Application no: H15/1473/00

Description: Proposed erection of 6 houses
with garages

Location: Town Drove
(Plots 16, 17, 18a, 18b, 19 & 20)
Quadrant
Spalding

NOTICE OF ACCEPTANCE OF AMENDMENT

DRAWING No.
99002/8,20,50- 01

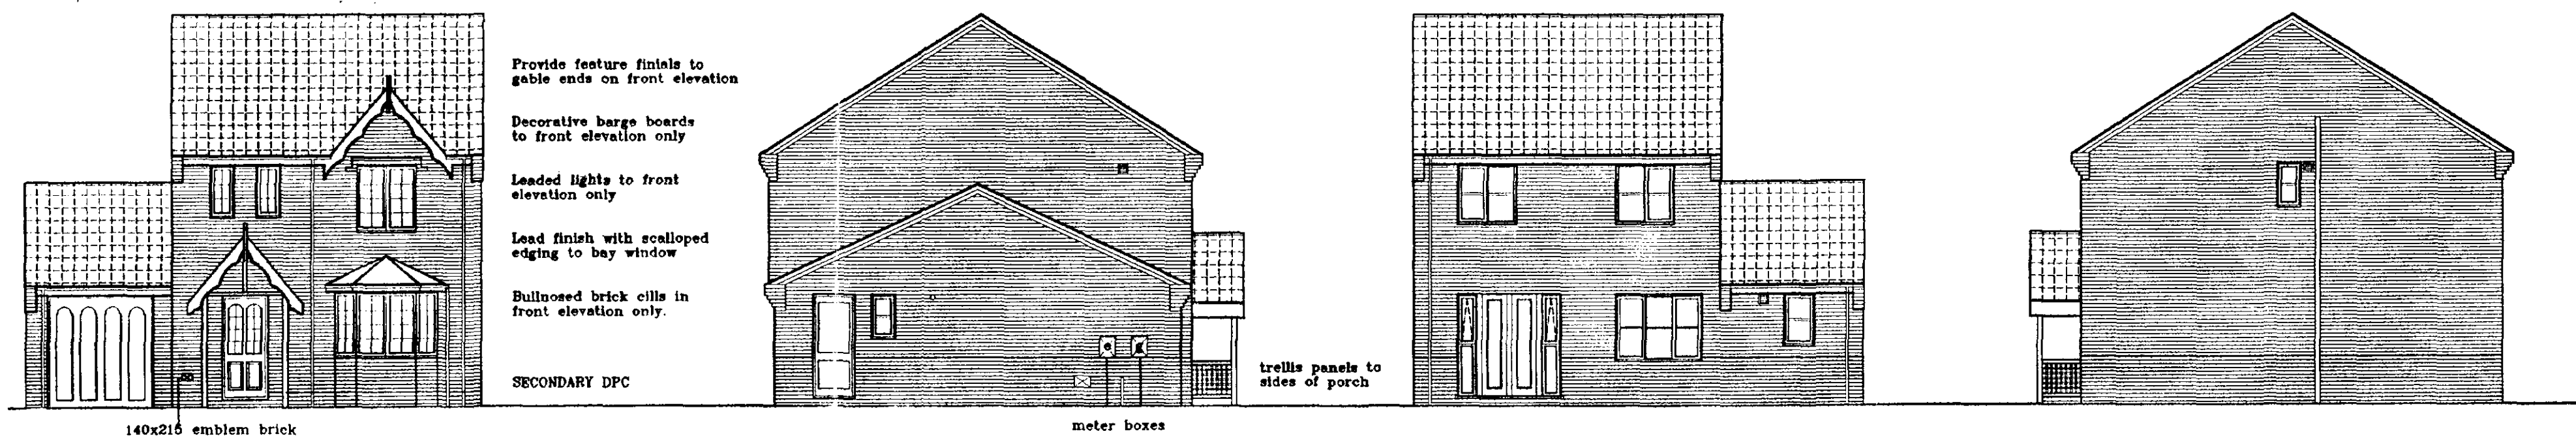
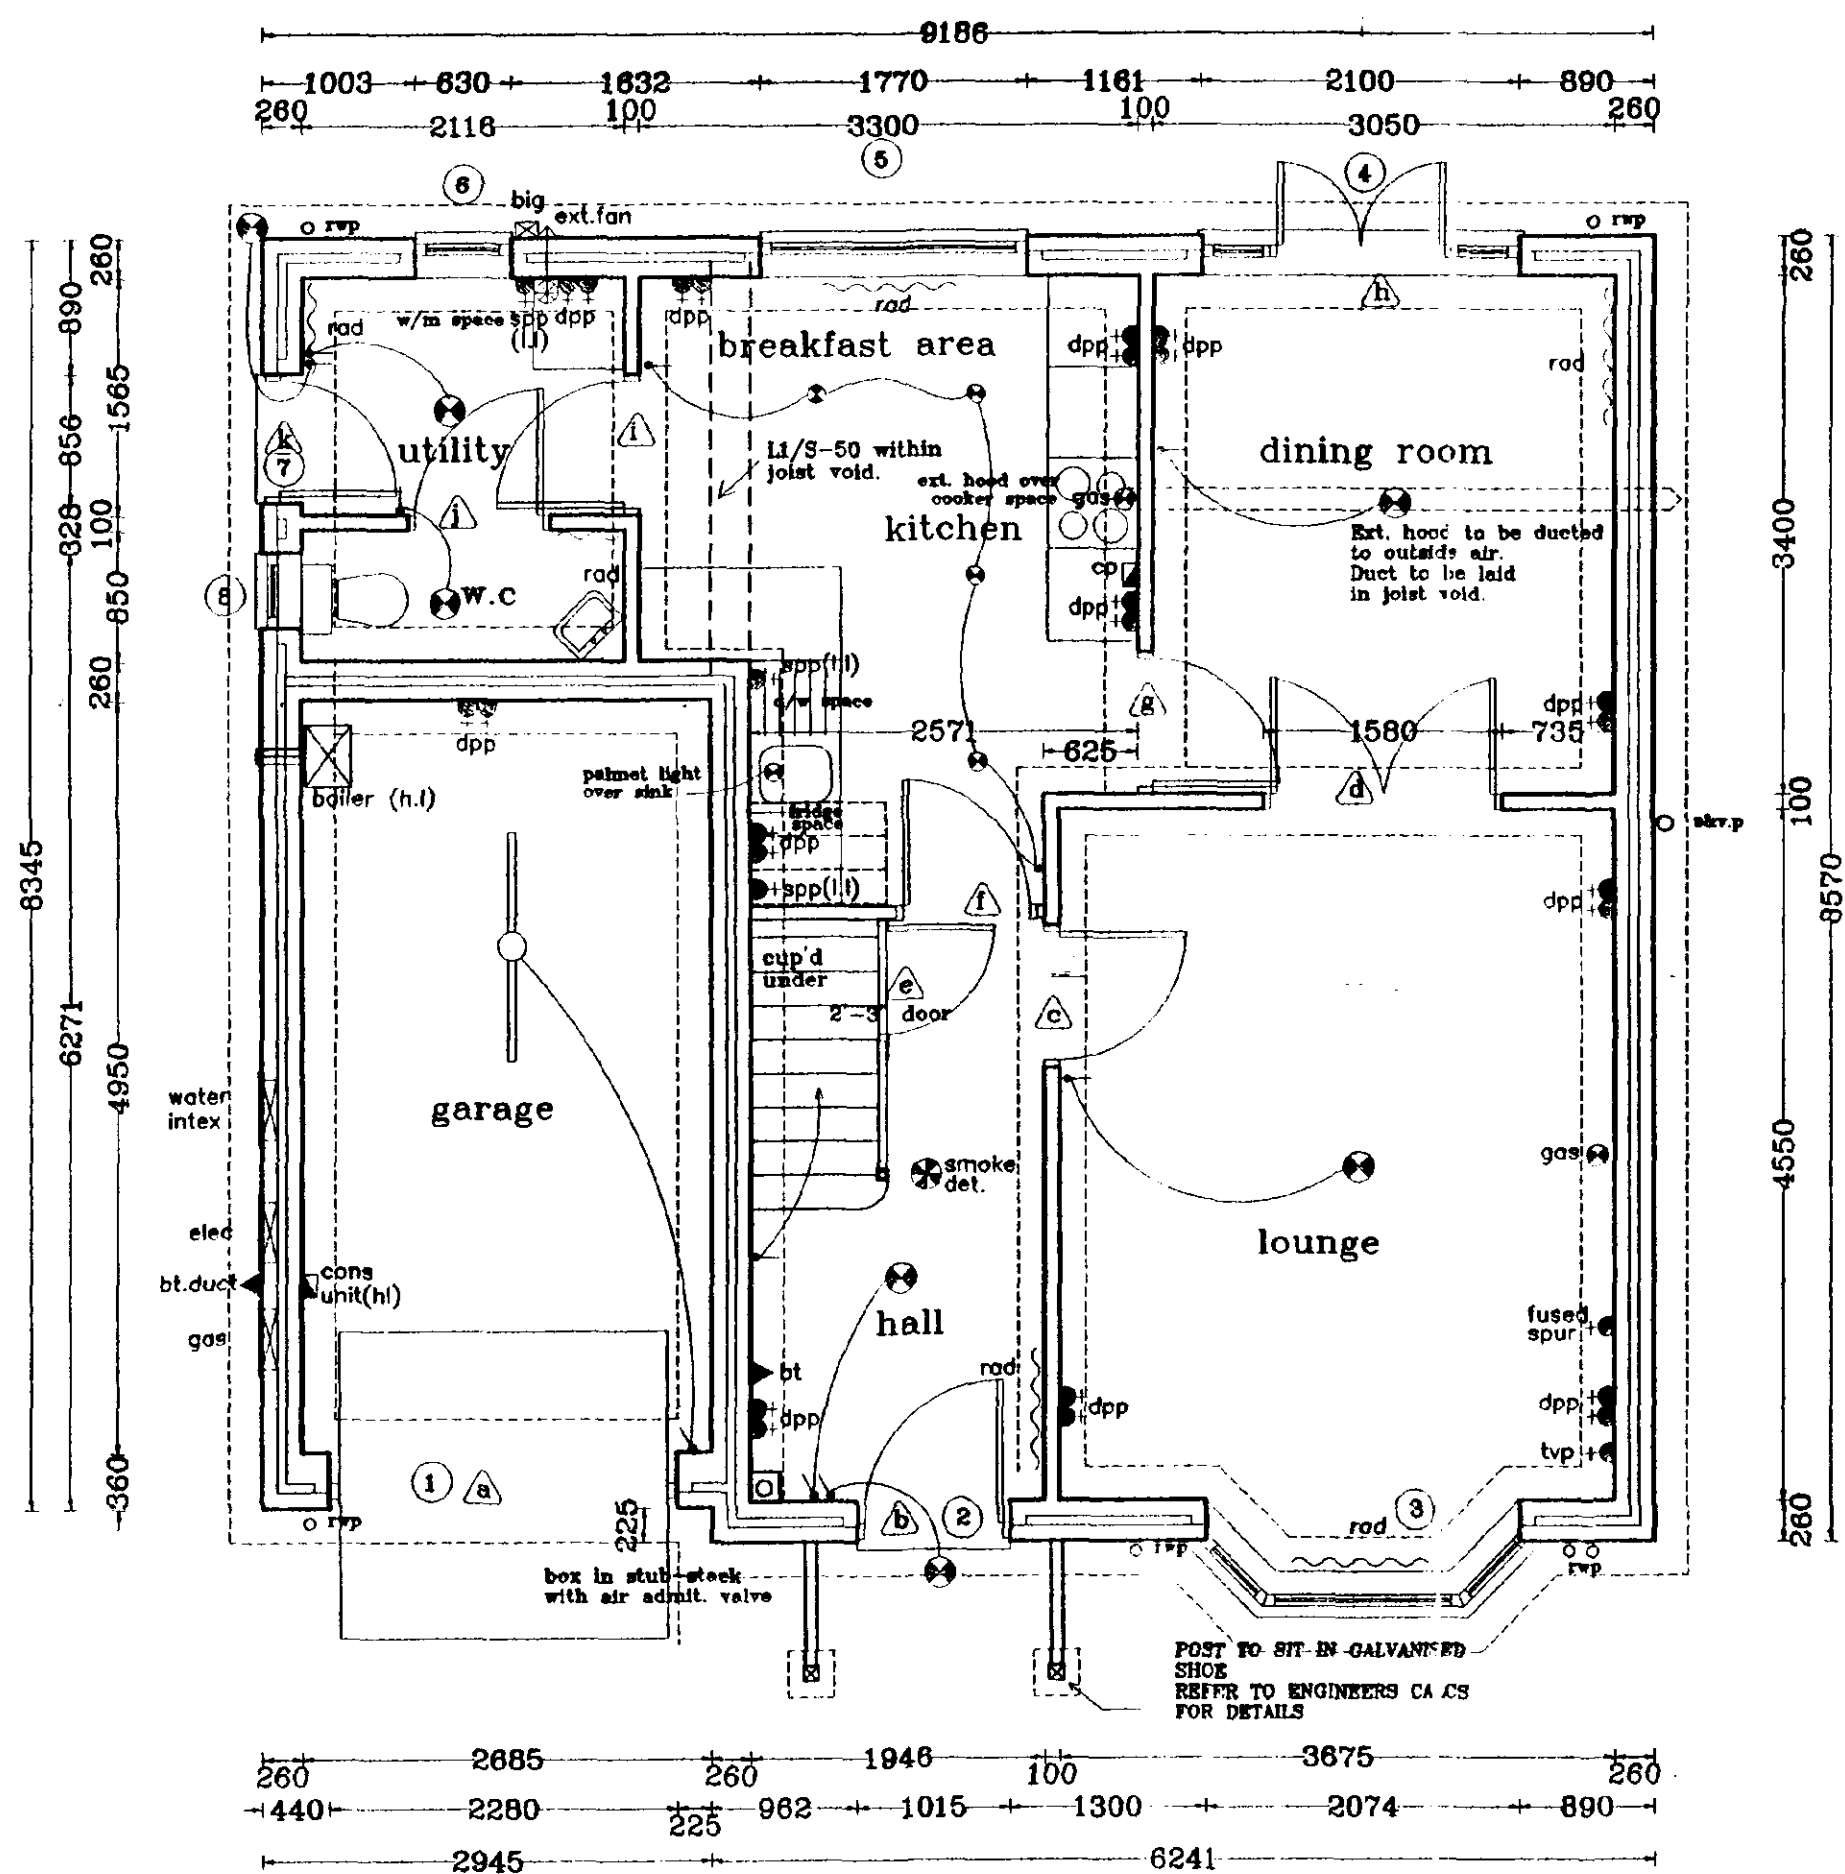
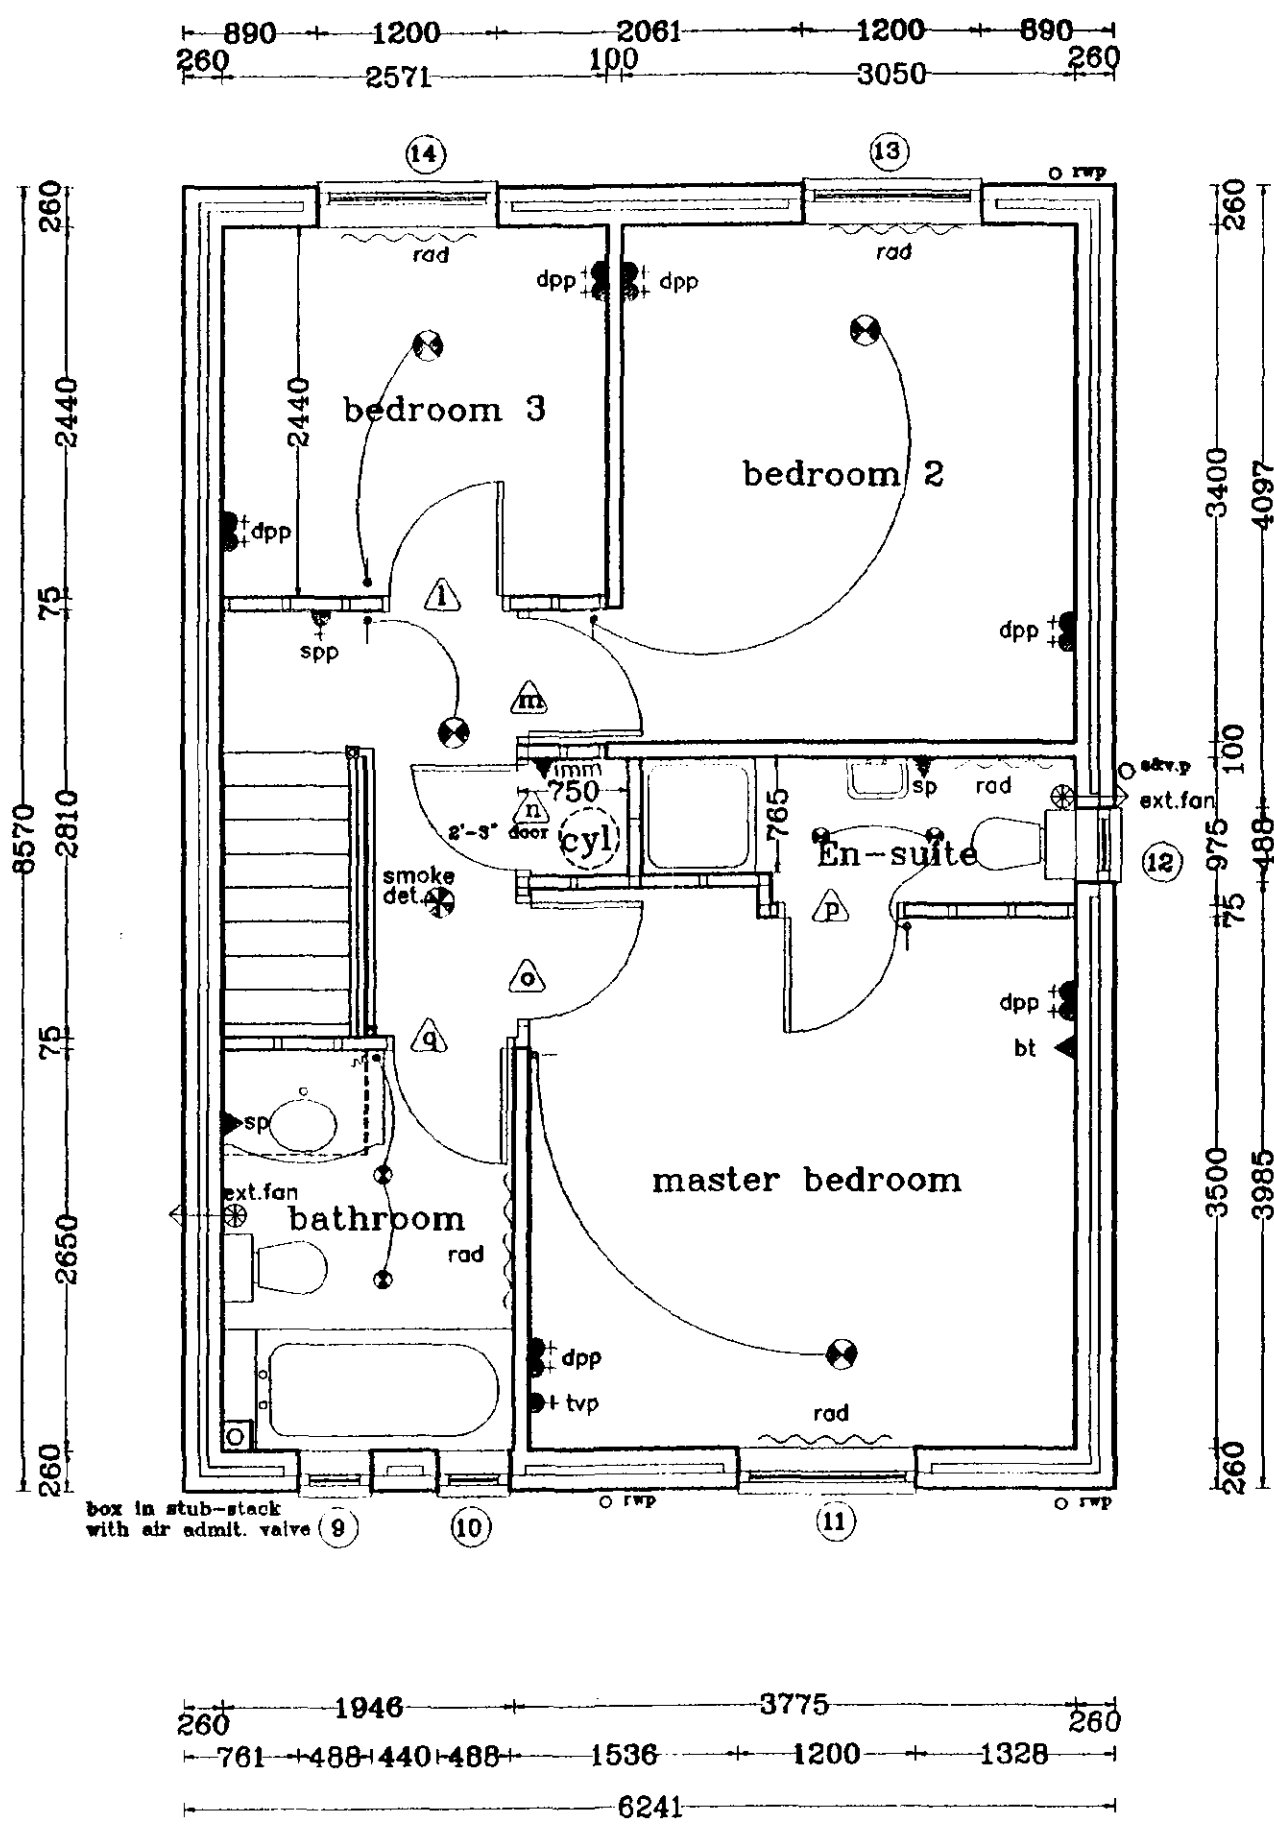
Amendment: Design modified (plot 20) - Minor changes to rear elevation
Dwg. nos. 99002/8,20,50-01 & 99002/SL

MINOR CHANGES - SEE PLANS.
to rear elevation

The amended details submitted in respect of the above proposal have now been considered and there are no objections to the amendment being implemented to the extent described above.
